LU/380/21/PL & LU/381/21/L

Regency Court Nursing Home 18-20 South Terrace Littlehampton BN17 5NZ

Replacement of 1 No PVCu window with a timber window to the rear (East) elevation. This application may affect the setting of a listed building, affects the Littlehampton Sea Front Conservation Area & is in CIL Zone 4 (Zero Rated) as other development.

Clients: Aster Court Nursing Home	
18-20, South Terrace, Littlehampton, BN17 5NZ	
Proposed New Window Details	
Scale: 1:20	Note: drawings not to be scaled from. Drawings are issued for planning purposes only.
GBS Design Services	Tel: 07918 638 510
20 November 2021 Geoff Brown MCIAT AssocRICS

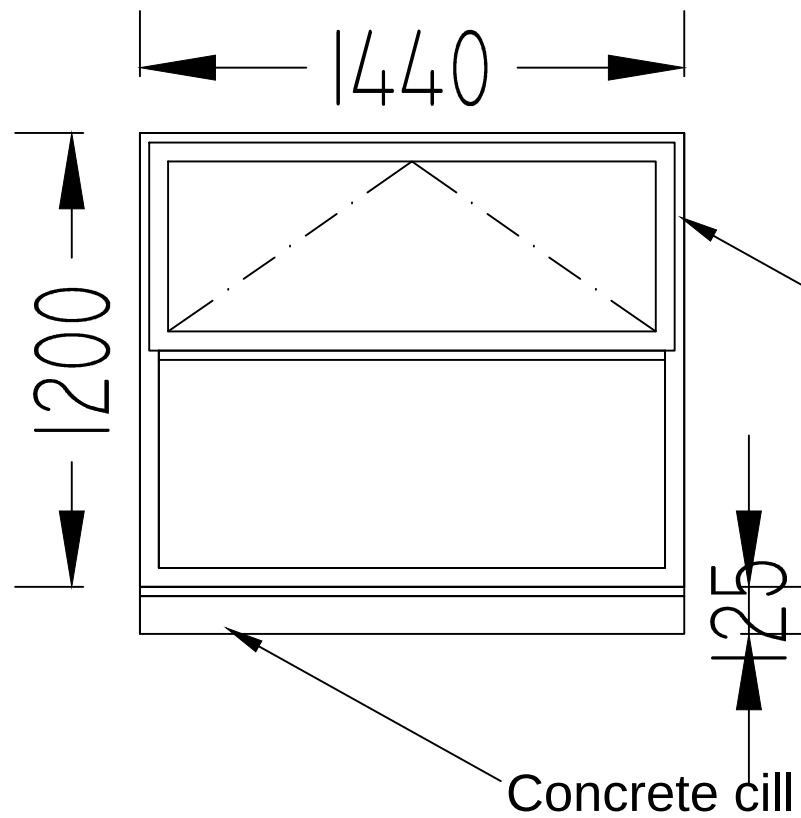
The proposal is to remove a UPVC window on the East elevation of the building and replace it with something more in keeping with the remainder of windows on that particular elevation. The existing windows (on this particular elevation) are clearly modern replacements being 'top hung' (or awning windows). The replacement window will be a timber one with a central horizontal dividing transom and painted white. Ideally the window would be a sliding sash, which would set the guide for the design of any other replacement windows in this particular part of the building in the future. However, based on the absence of this design on this particular elevation, and that the window is also not clearly seen from the public domain, I am of the opinion that this design is acceptable in this instance. It is worth stressing that this should not be seen as a justification to allow use of this design elsewhere either in this building or the conservation area.

On balance, the application is considered to not cause harm to the significance of the heritage assets or their setting. As a consequence, it should be determined in accordance with the relevant policies within the Development Plan, along with these comments. You will also need to take into account the contents of the Planning (Listed Buildings and Conservation Areas) Act 1990 (as amended).
